***Vincentia District Centre – Corner Naval  
College Road and The Wool Road  
MP 06\_0025 MOD 4***

***Modification Request***

Modifications to the building footprint, finished floor level, roofline, internal mall widths, materials and finishes, loading dock and car parking.

Director-General's  
Environmental Assessment Report  
Section 75W of the  
*Environmental Planning and Assessment Act 1979*

Figure 2: Street Cross Section of Existing and Proposed Setback to Moona Creek Road

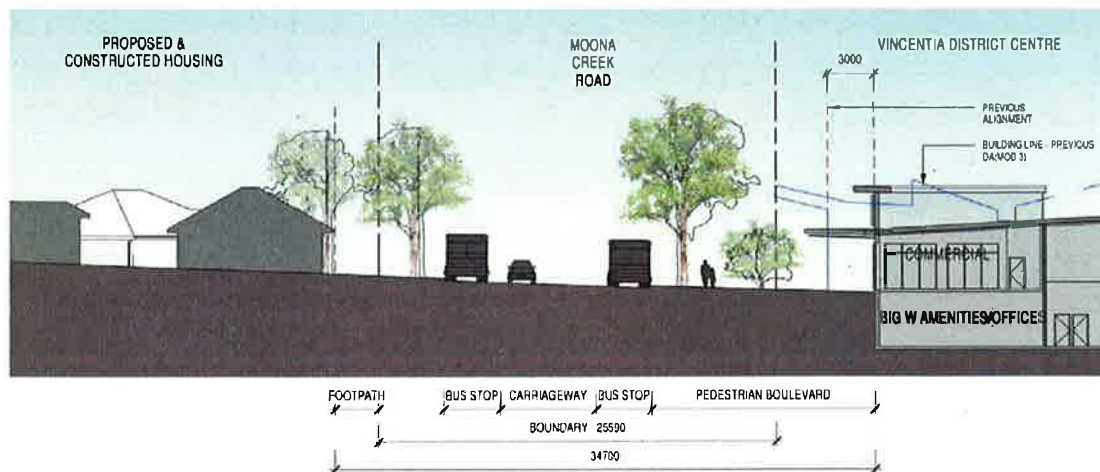
The proposal includes increasing the setback of the external walls of the specialty tenancies abutting the Wetlands on the north eastern façade by 5m. It is also proposed to increase the setback along Moona Creek Road by 3m.

As the above street cross section shows, the proposed additional 3m setback to Moona Creek Road appears minor in comparison to the overall width of the street. The proposed modification will not impact the original design intent of the concept of the 'gateway building' as the scale and façade treatments are being retained.

A. INDICATIVE SECTION THROUGH BOARDWALK - NTS

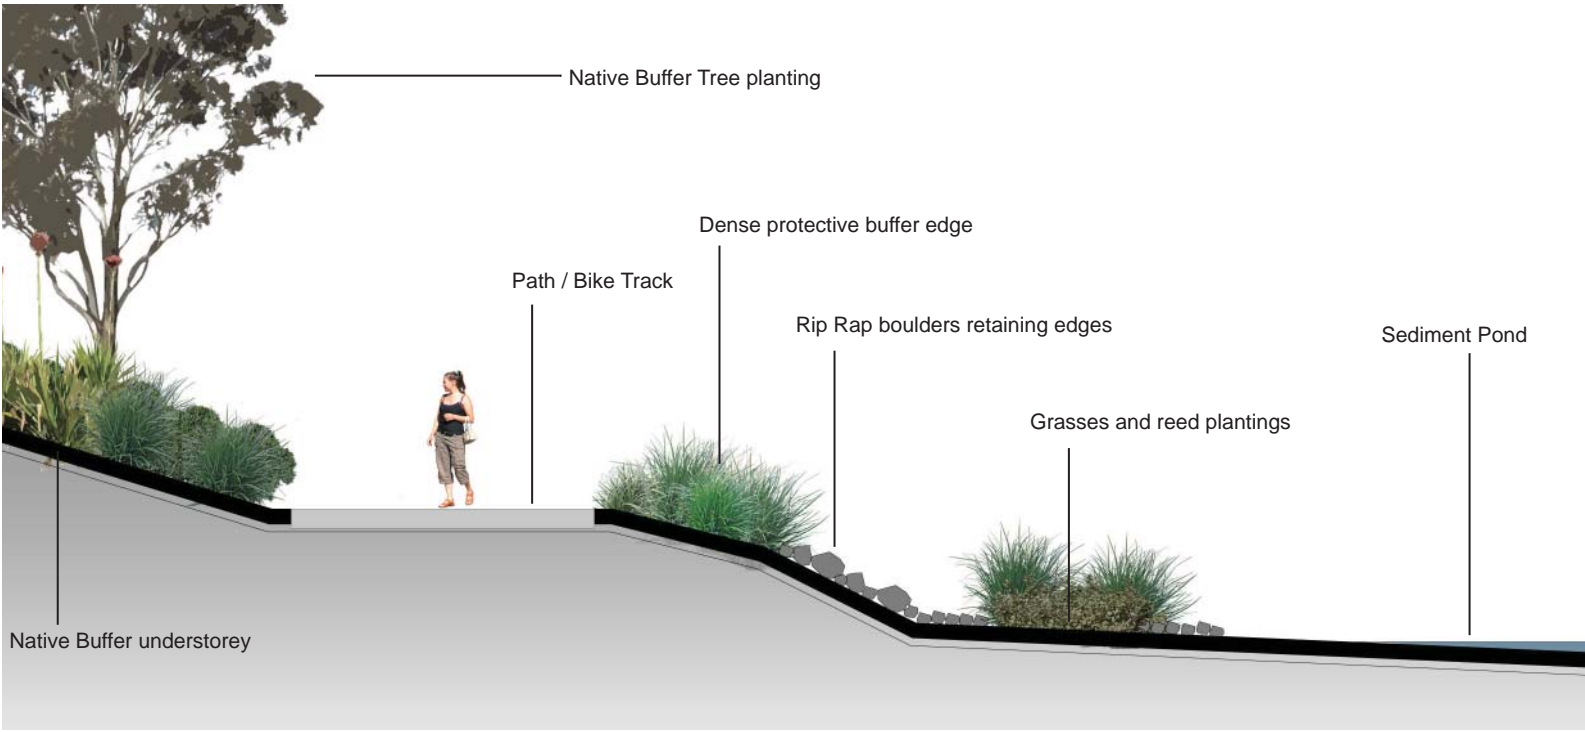
| Issue                                                                                                                                                                                                                                                                                                                                                                                                                                                                    | Comment                                                                                                                                                                                                                                                                                                                                                                                                                                                                                             |
|--------------------------------------------------------------------------------------------------------------------------------------------------------------------------------------------------------------------------------------------------------------------------------------------------------------------------------------------------------------------------------------------------------------------------------------------------------------------------|-----------------------------------------------------------------------------------------------------------------------------------------------------------------------------------------------------------------------------------------------------------------------------------------------------------------------------------------------------------------------------------------------------------------------------------------------------------------------------------------------------|
| <ul style="list-style-type: none"> <li>• <b>WSUD</b><br/>Changes to the configuration of the bio-swales in the car park which will reduce the number of bio-swales being from every car park row to every alternate car park row.</li> </ul>                                                                                                                                                                                                                             | <p>The area (cubic capacity) of the bio-swales has been increased to compensate for the reduction in number of bio-swales. The modification will improve the efficiency of the catchment system and ensures that the use of the bio-swales and detention dam in the main car park has been maintained.</p> <p>Council will be responsible for approving the final design at Construction Certificate stage.</p>                                                                                     |
